Royal Randwick Racecourse
Proposed Hotel, Access, Parking and Bus Access Information

This letter has been prepared to address the issues highlighted by Department of Planning (DoP) and the Roads and Maritime Authority (RMS) in relation to the proposed Hotel development within the Royal Randwick Racecourse site. The ATC and PTC presented the proposal and the following responses to DoP and RMS on 8 November as a powerpoint presentation, which provided the opportunity for all present to discuss the proposal and ideas/comments that the design team could consider.

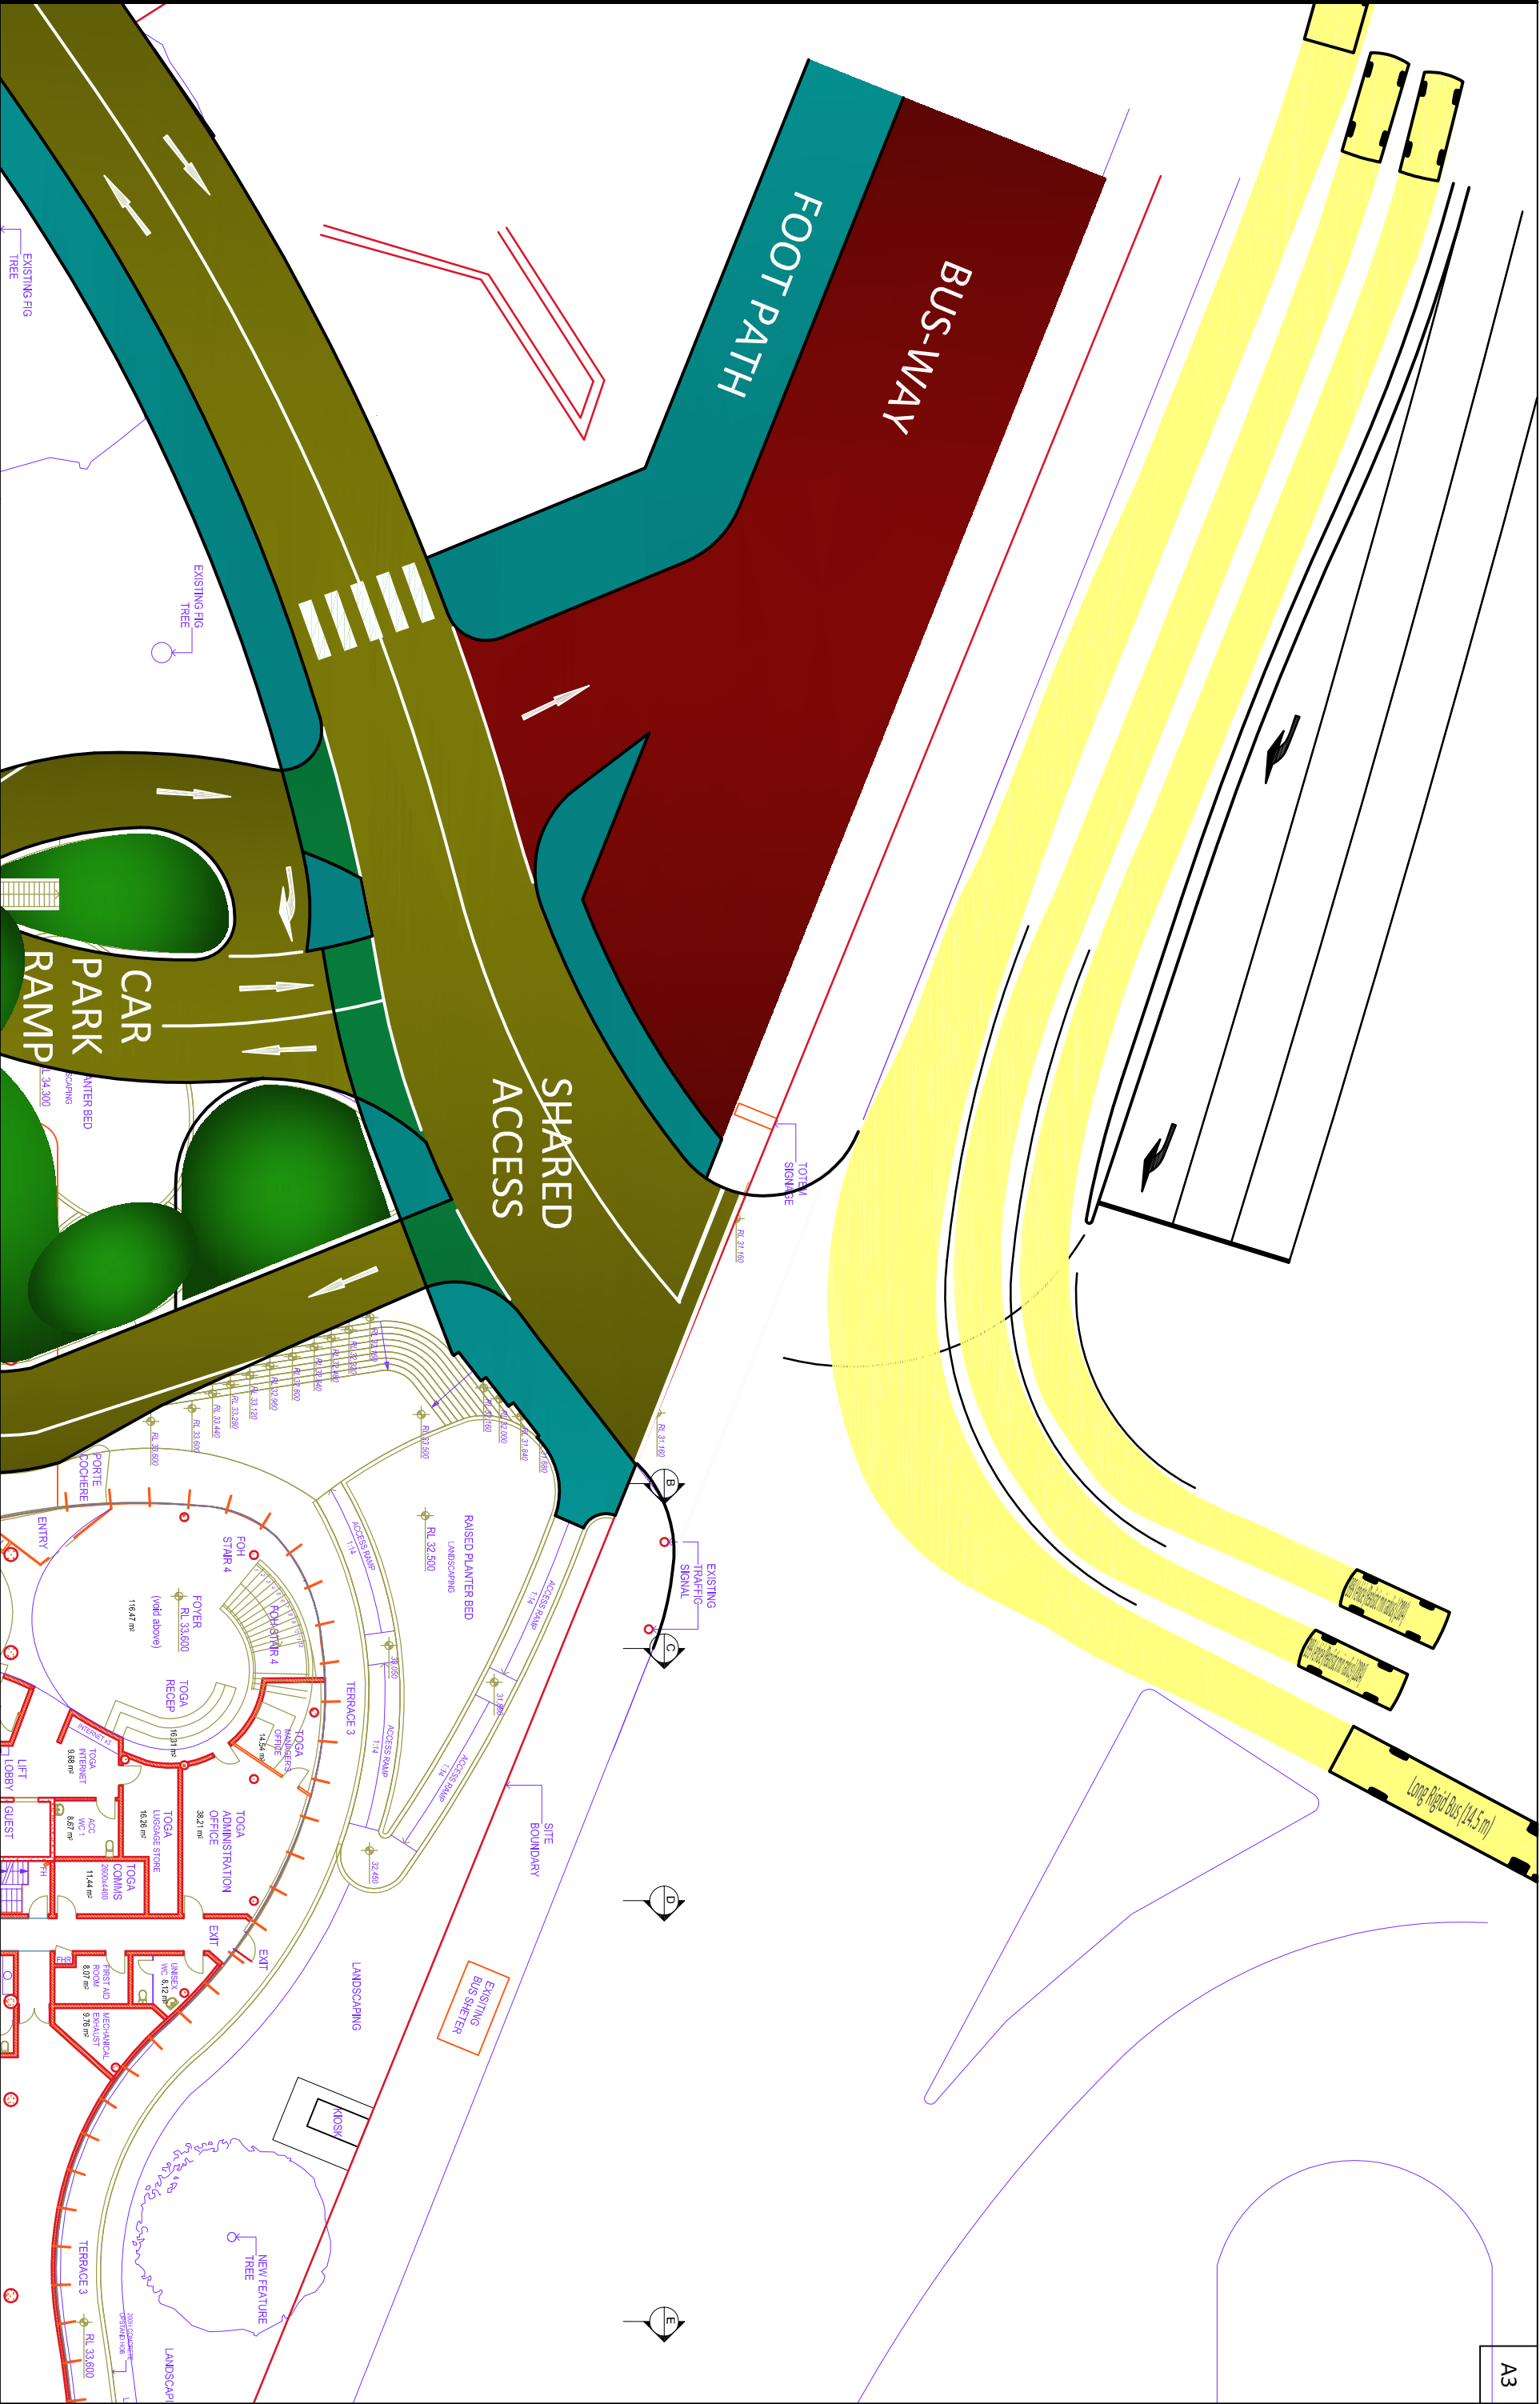
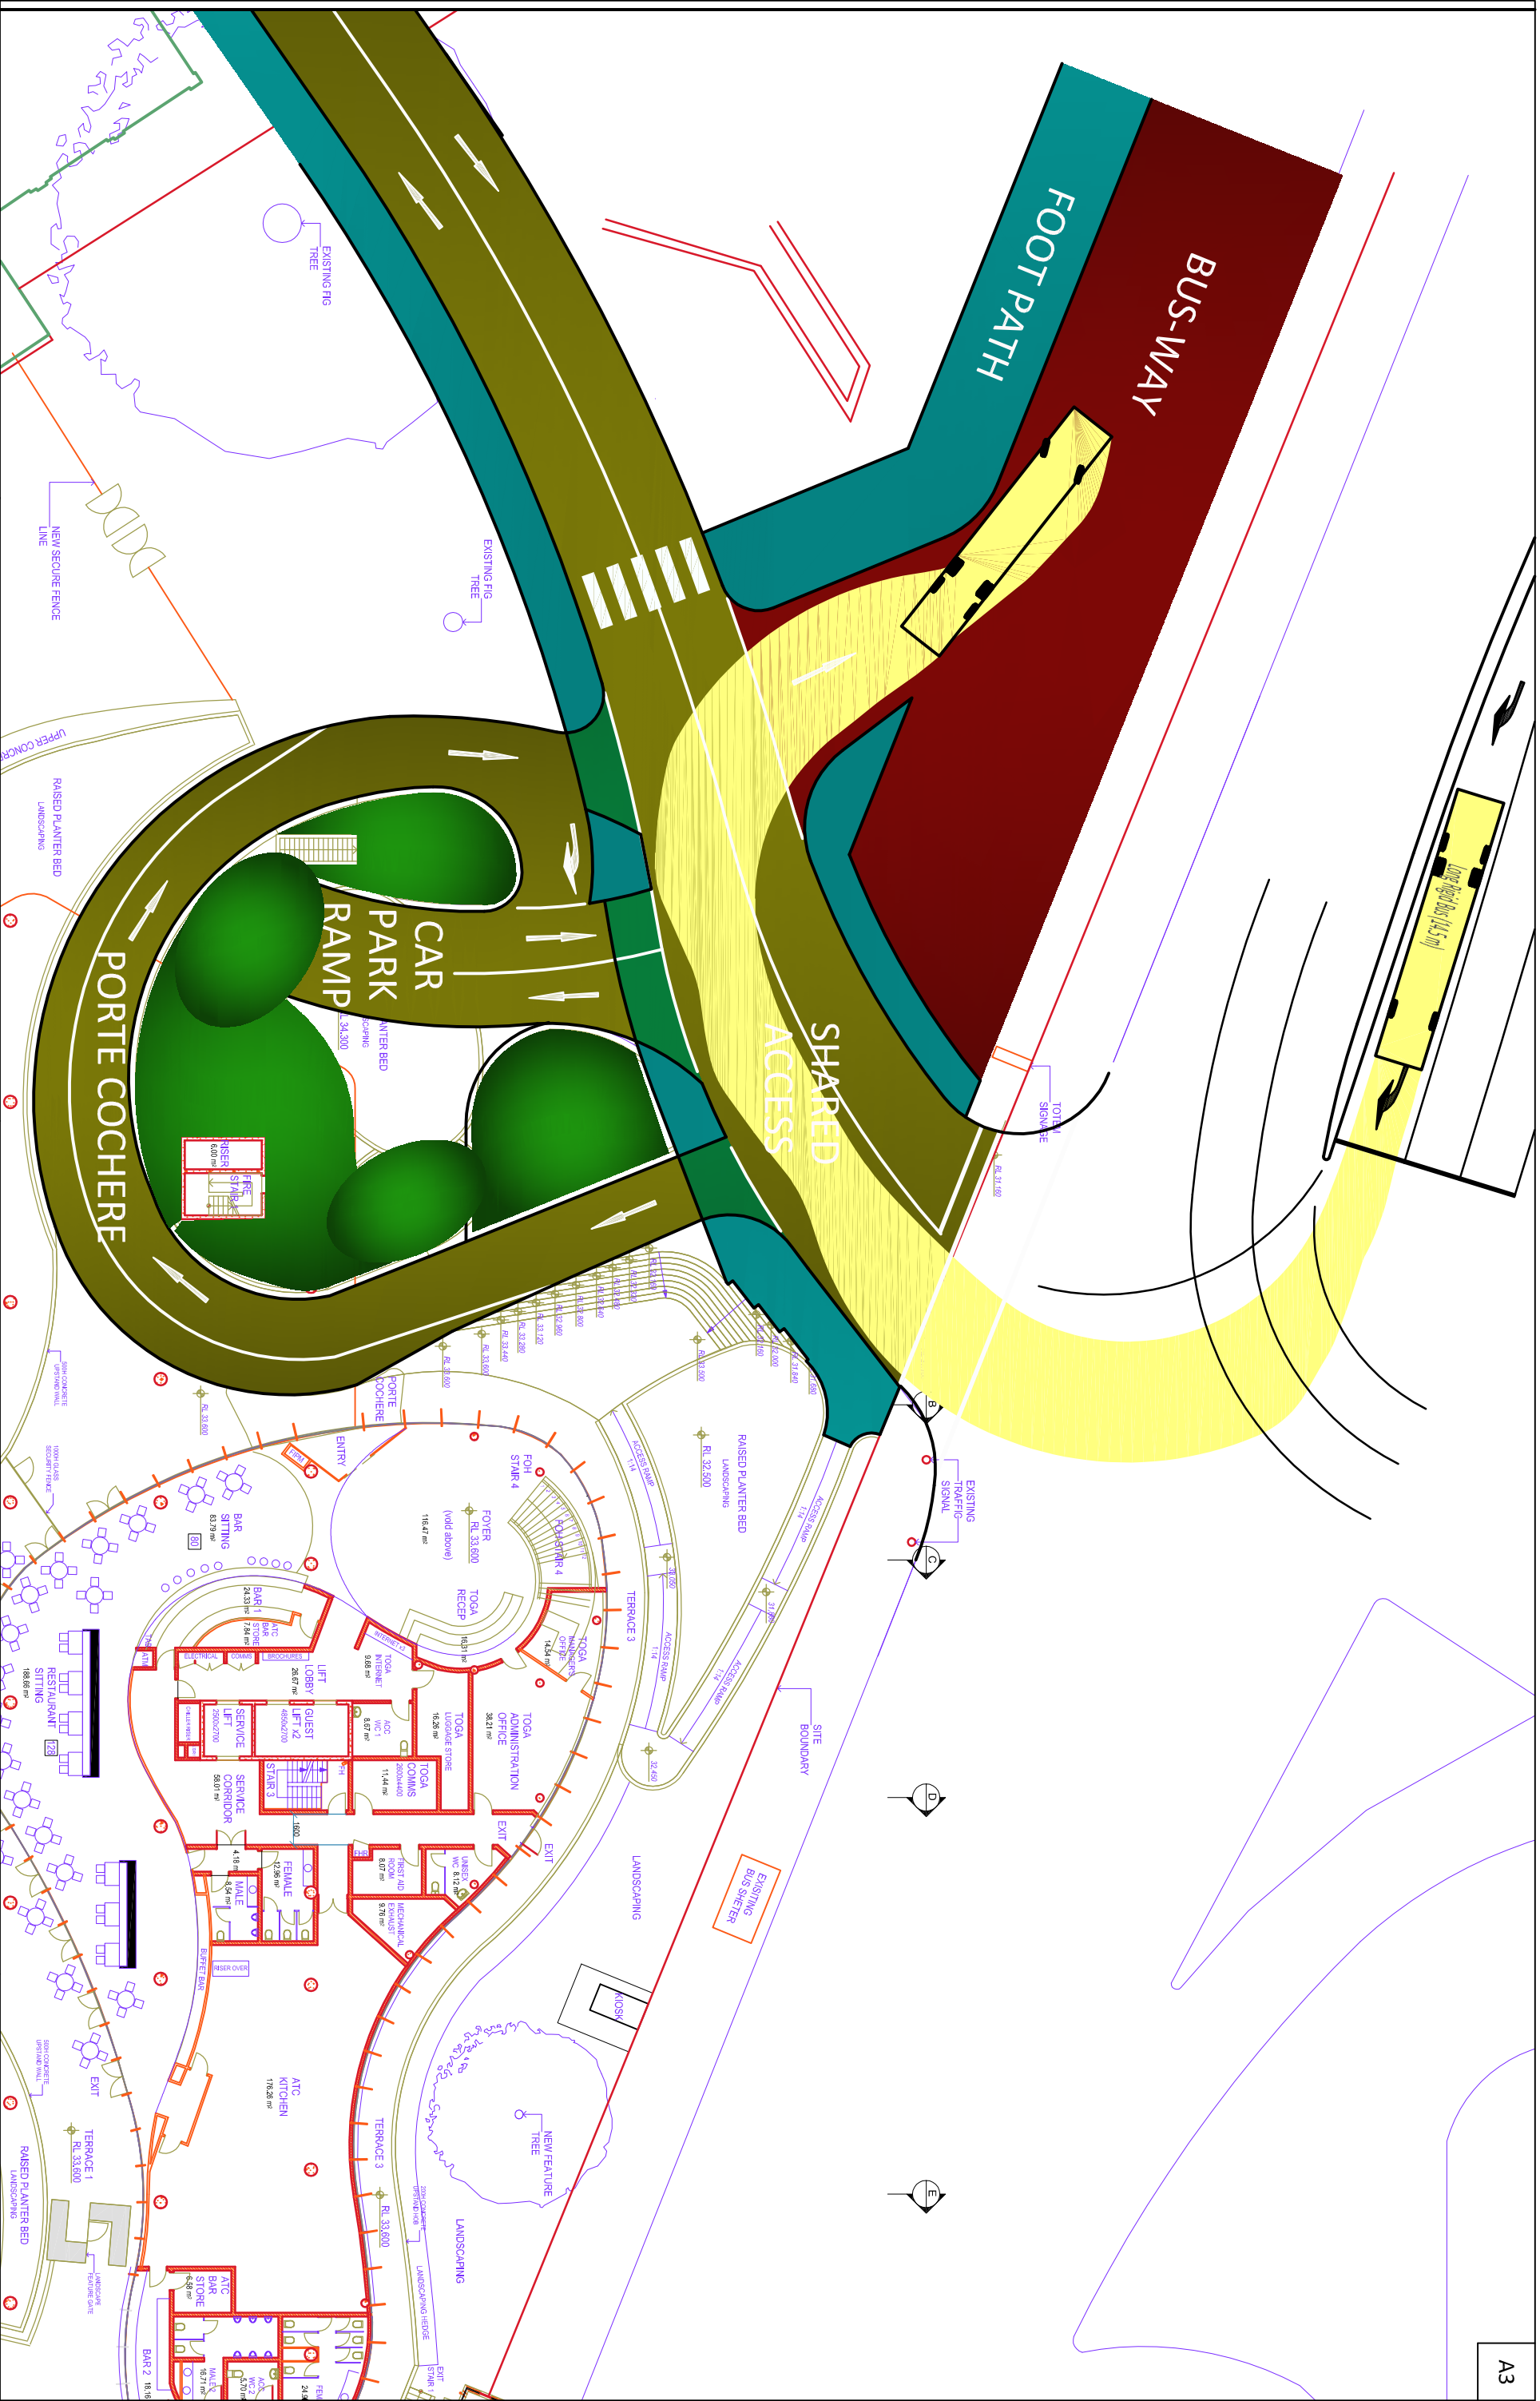
The proposed right turn into the site from Alison Road is not supported due to potential negative impacts on the surrounding road network and bus operations. An alternate arrangement should be considered to accommodate expected additional traffic without impacting on the existing road network. Any proposed alternate access arrangement should be supported by details of any SIDRA Modelling used, scaled plans illustrating adequate lane widths and vehicle turning circle into the site.

In conjunction with the traffic assessment submitted with the Development Application, a SIDRA analysis was prepared in order to determine the operation of the intersection before and after the hotel development. The modelling confirms that the 95th percentile queue for the site access right turn was 0.7 vehicles during the morning peak and 0.5 vehicles during the evening peak, indicating the proposed right turn lane length of 25 metres (excluding taper). The length of the right turn lane is sufficient to accommodate the queuing expected during normal operation, but will accommodate two 12.5 metre long

buses when in use in relation to the bus-way. We have prepared microsimulation modelling, which demonstrates that no more than two buses arrived at one time over the period of the modelling. This was based on the peak bus volume (26 buses in 1 hour) superimposed over the peak traffic volumes associated with the Epsom Super Saturday. To provide a sensitivity test, we then doubled the number of buses, which indicates that up 58 buses per hour can arrive via the intersection with no more than 2 buses being queued. The management of bus arrivals is also an important aspect of the proposed arrangement, which is discussed in detail further below.

Swept paths are shown as **Attachment A**, demonstrating that all movements can be undertaken by the appropriate vehicles, including the right turn from Darley Road by a bus in the outside lane, along with two cars in the inside lanes.
